Subject: "Leisure Route 6.7km to Fritwell" through working farmyard - Troy Farm OX25 6NG

These are my comments on the proposed planning at Heyford Park to go on the website.

FIGURE 6.2a
PEDESTRIAN AND CYCLE CONNECTIONS
 27/02/2020
 SCALE: NTS @ A3

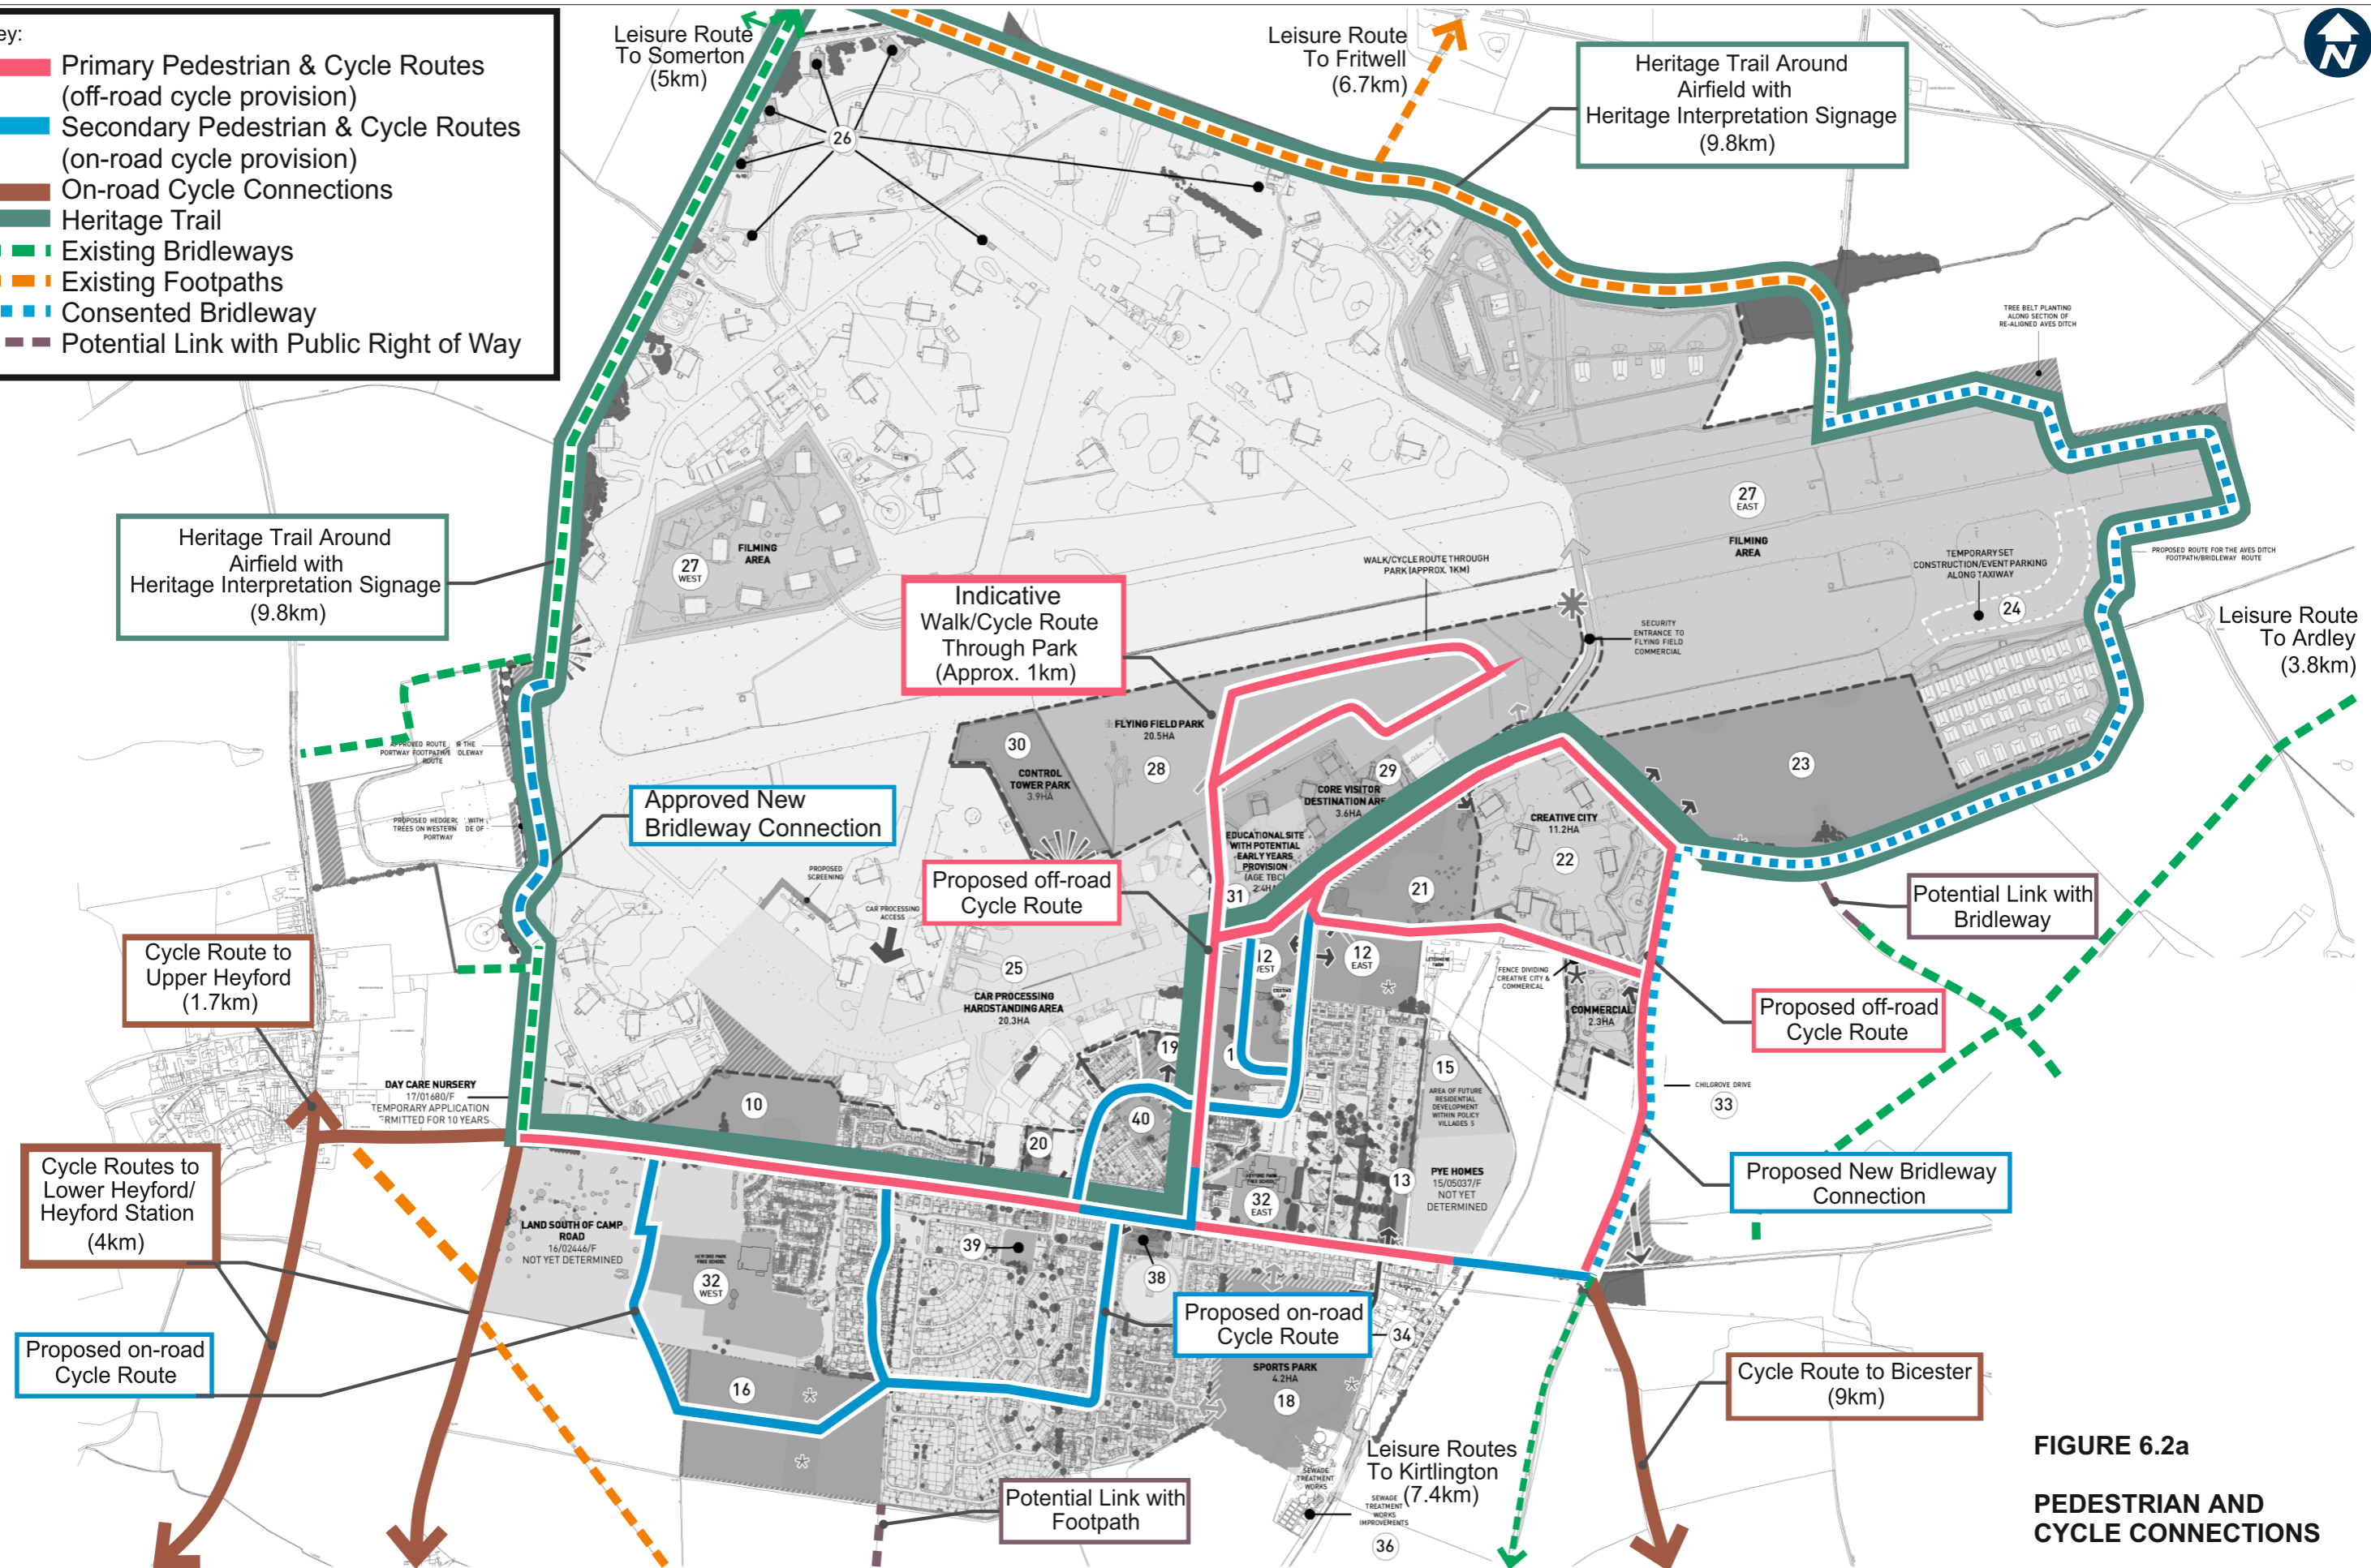
The HP plans to improve connectivity to and from HP into the wider neighbourhood and surrounding villages as stated in the TA 5.3.6 are positive however I have reservations regarding some of the proposals which I feel need more clarification particularly the Heritage Trail.

I have talked to many people to try and get a balanced view regarding the proposal to name an established footpath a Leisure Route 6.7km Fritwell going from the Northern boundary fence footpath through the working farmyard at Troy Farm .

I fully support the footpath network around the countryside but an advertised leisure route going through an active farmyard particularly busy in the summer with agricultural machinery, horses and more people walking is not appropriate and there will be Health and Safety issues despite notices.

An advertised "Leisure Route to Fritwell" on a well-known footpath with the local walkers may not be what families and walkers from outside the area will appreciate as they go through six gates, a narrow bridge, busy farmyard and a stile.

Simon Fry from Dorchester Group mentioned that he may be able to relocate the Leisure route. I would be very happy to engage in any further discussions as I feel very strongly about the workings of this proposal.
